# ***City of Albuquerque***

***RE: LOT 408-A (J14-D125). GRADING AND DRAINAGE PLAN FOR SITE DEVELOPMENT PLAN, BUILDING PERMIT, AND CERTIFICATE OF OCCUPANCY APPROVALS. ENGINEER'S STAMP DATE IS NOT LEGIBLE.***

Based on the information provided on your December 8, 1997 submittal, City Hydrology has the following comments:

GRADING AND DRAINAGE PLAN  
LOT 408-A  
718 MOUNTAIN RD. NW

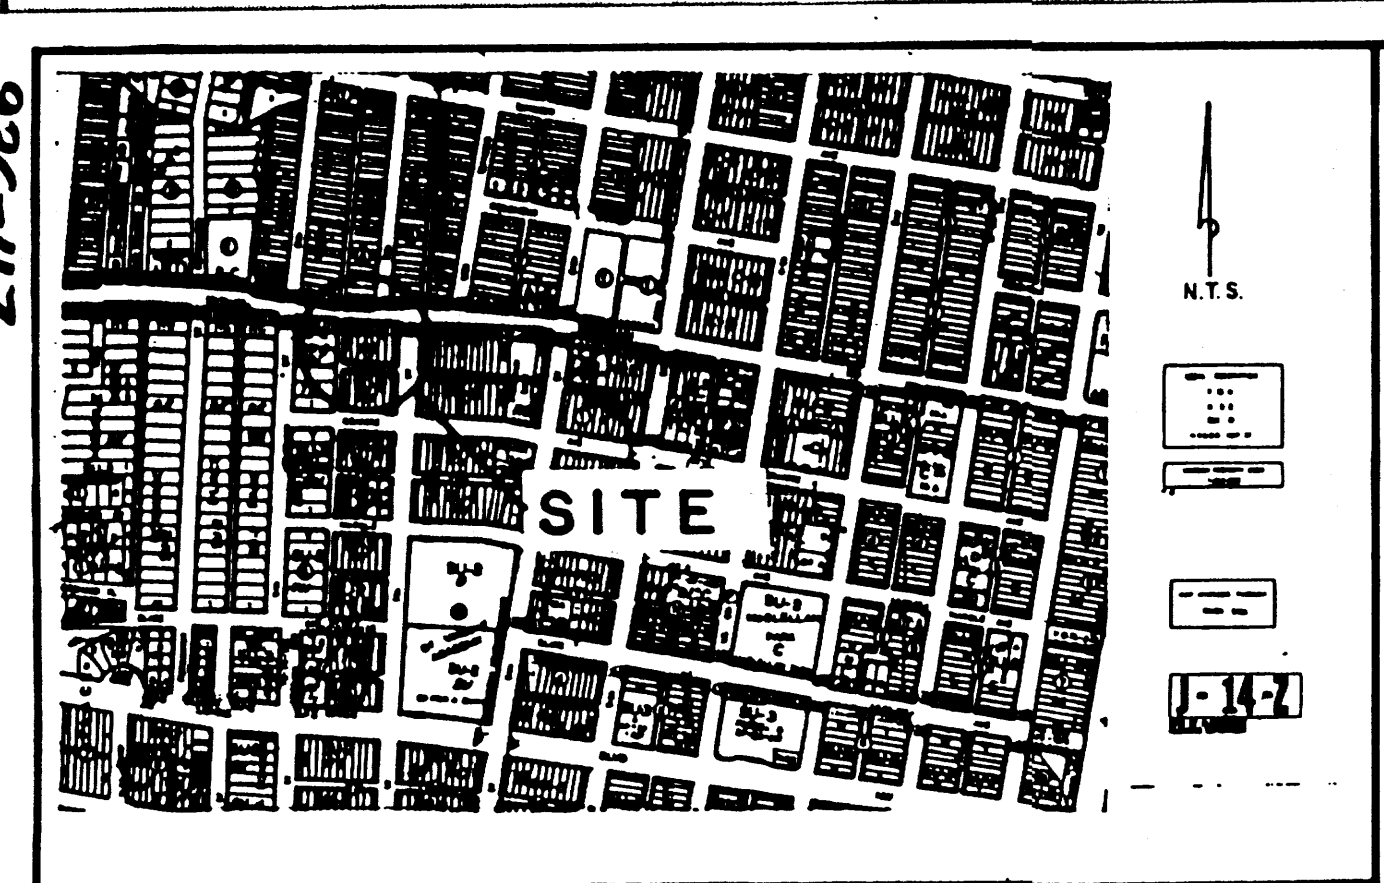
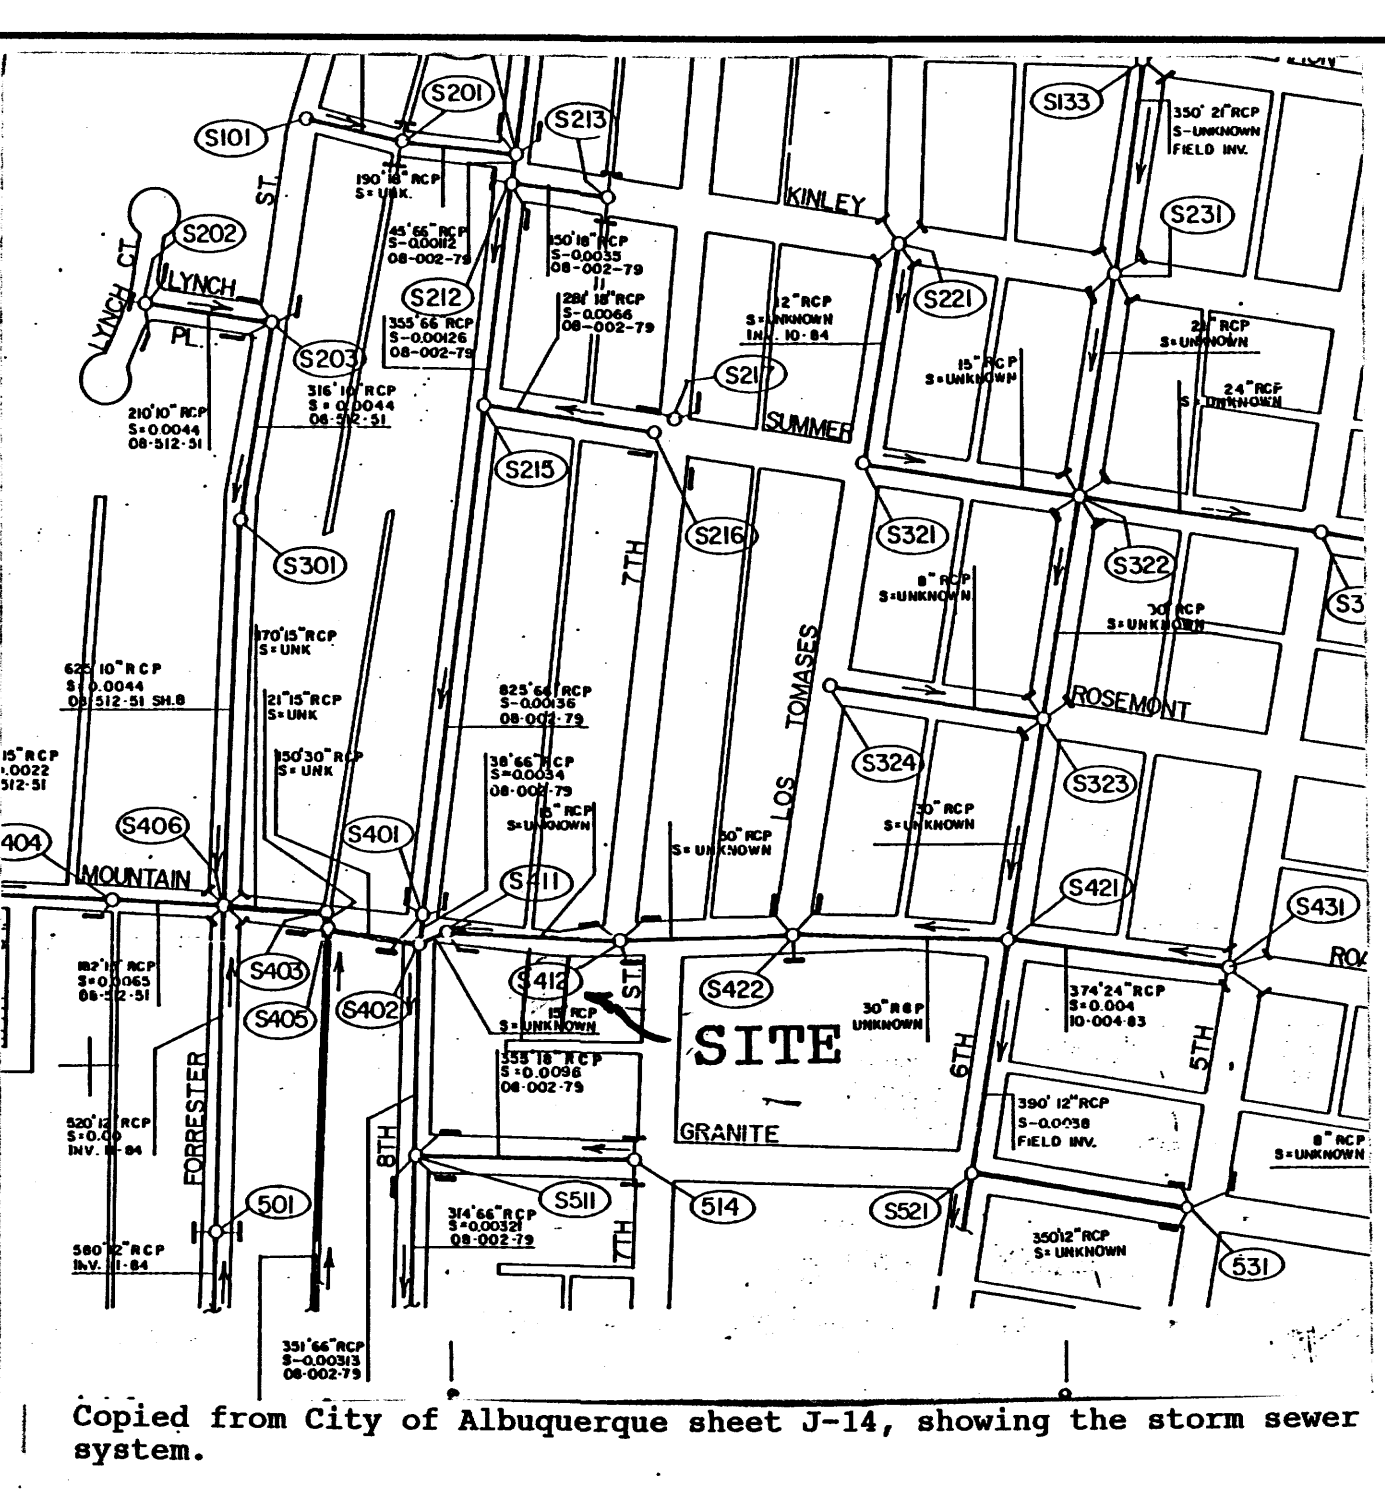
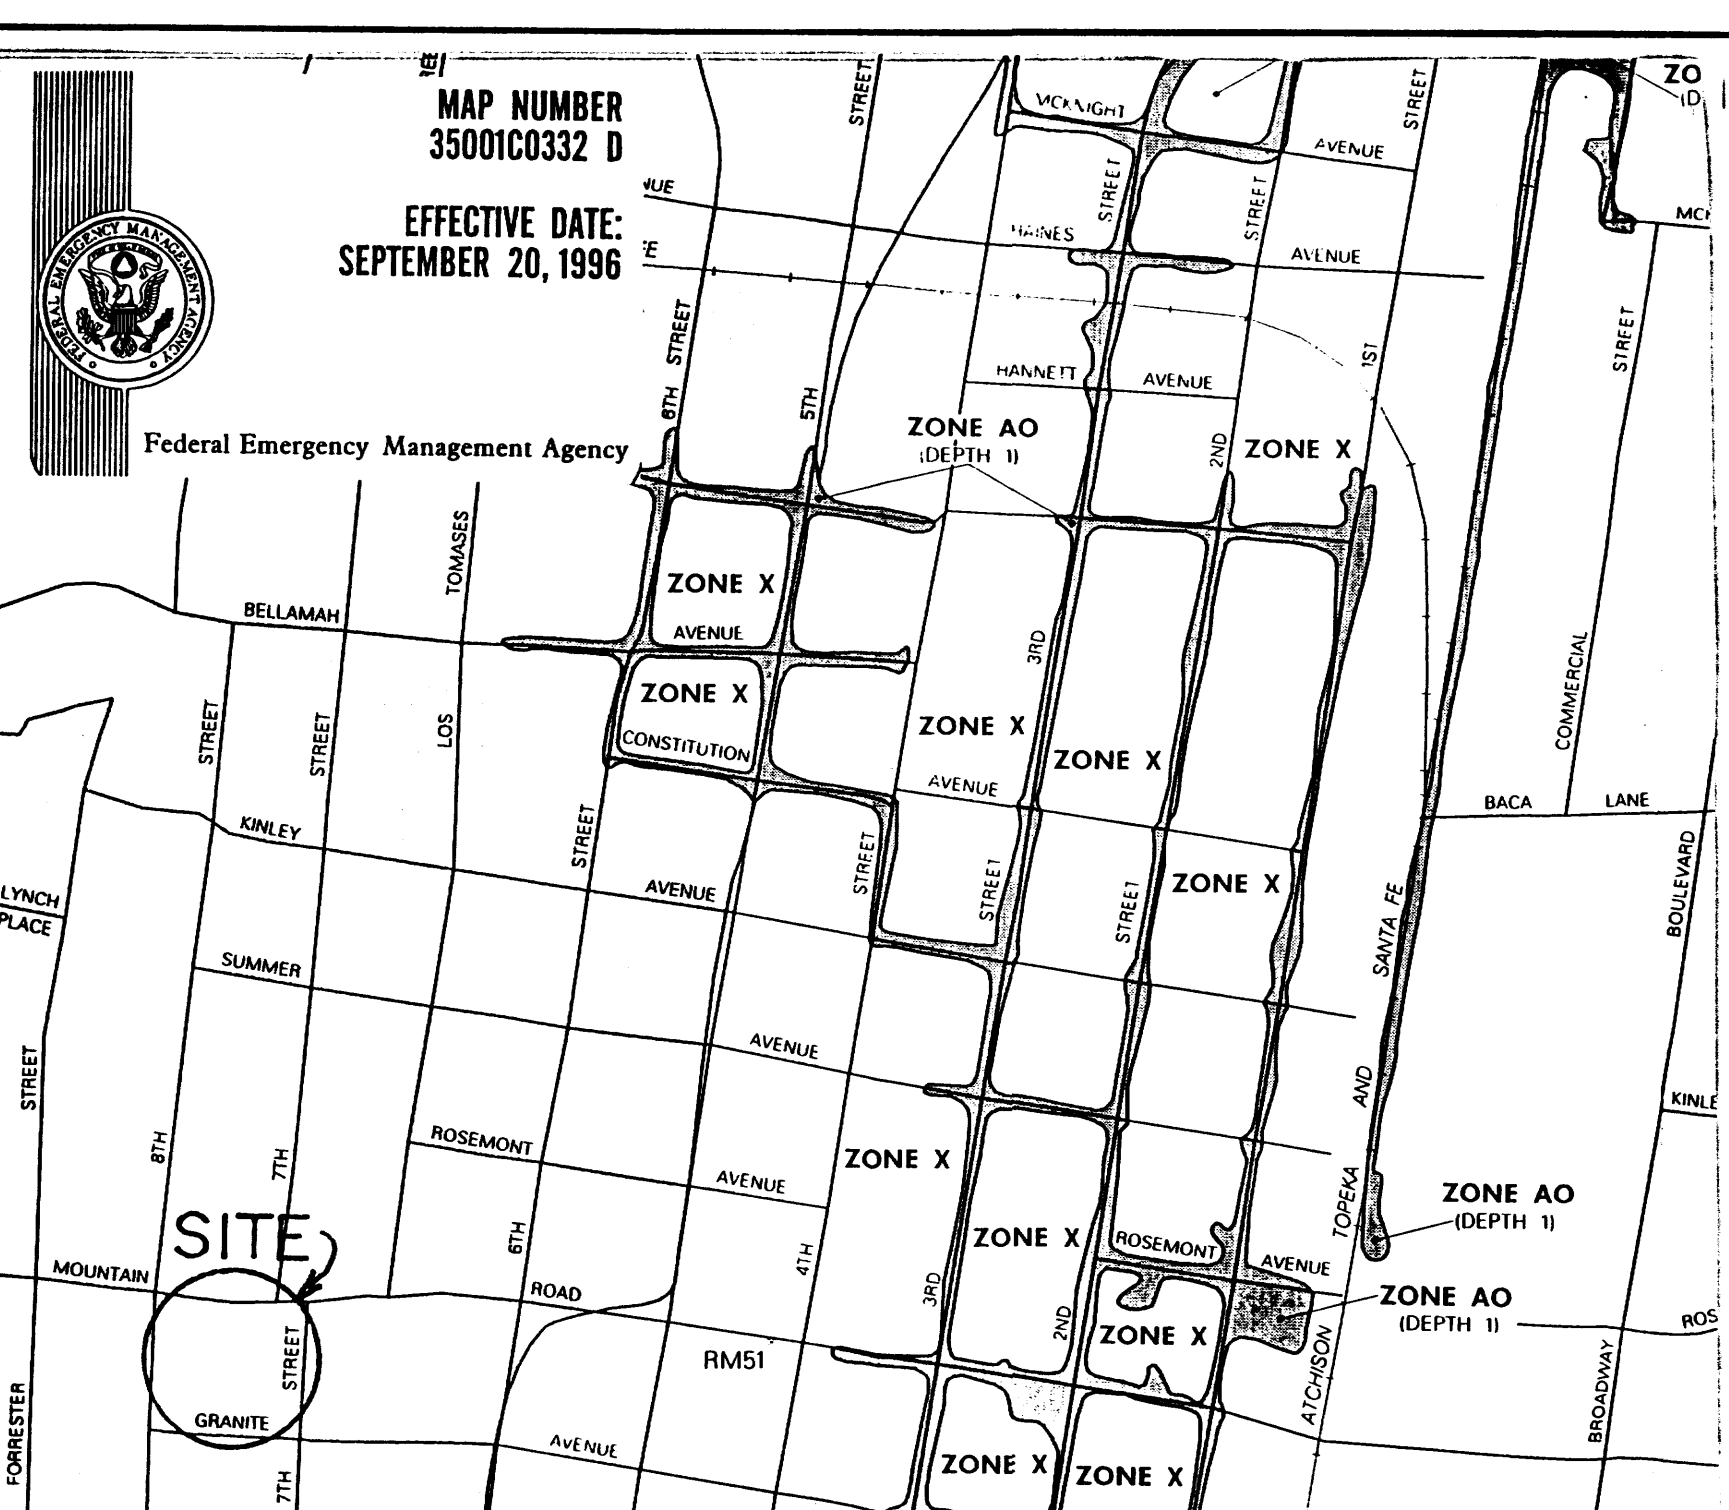
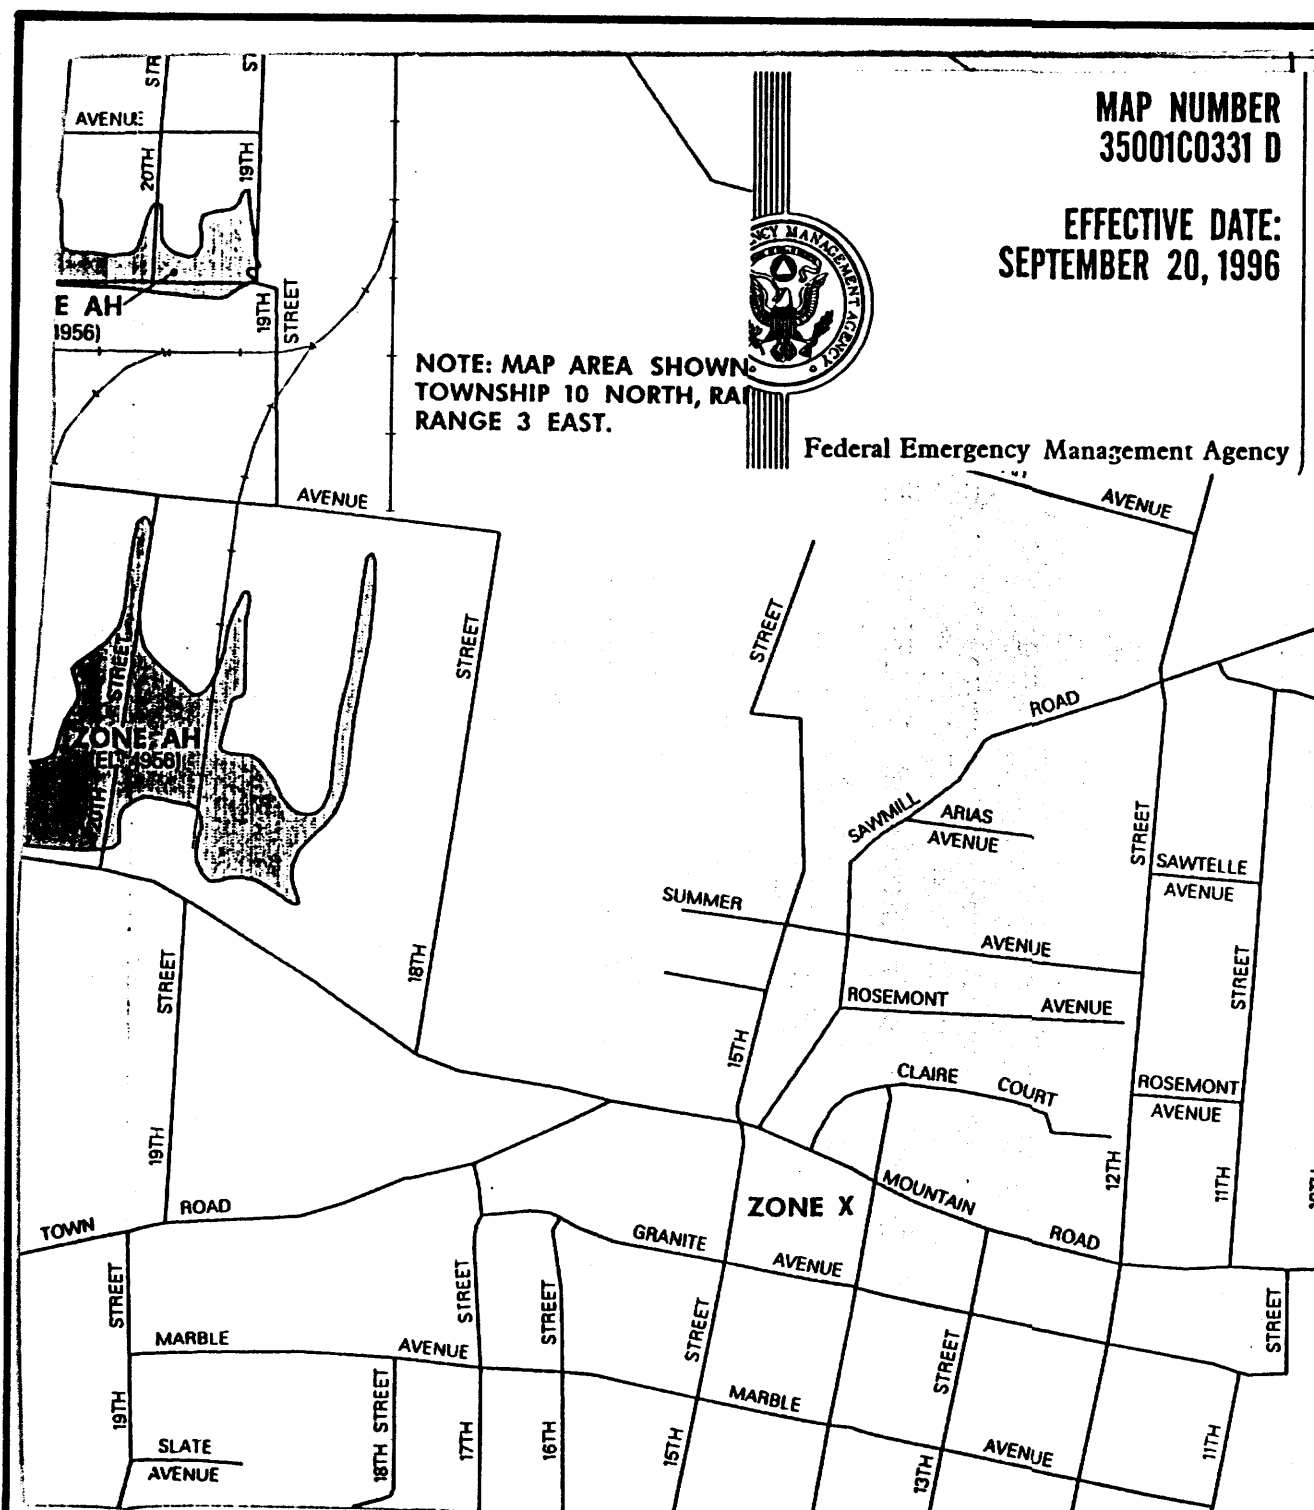
1. It appears that this site is developed with buildings 1 - 4. I am unable to tell what you want you propose to build. Why do you need a Building Permit?
2. What type of Site Development approval are you seeking?
3. Provide a legend.
4. Are you providing enough right-of-way for the City to install a sidewalk?

In general, I am not certain why you need any approval from Hydrology. It appears to me that you propose to install roof drains and garden walls. Are you doing any grading? If I can be of further assistance, please feel free to contact me at 924-3984.
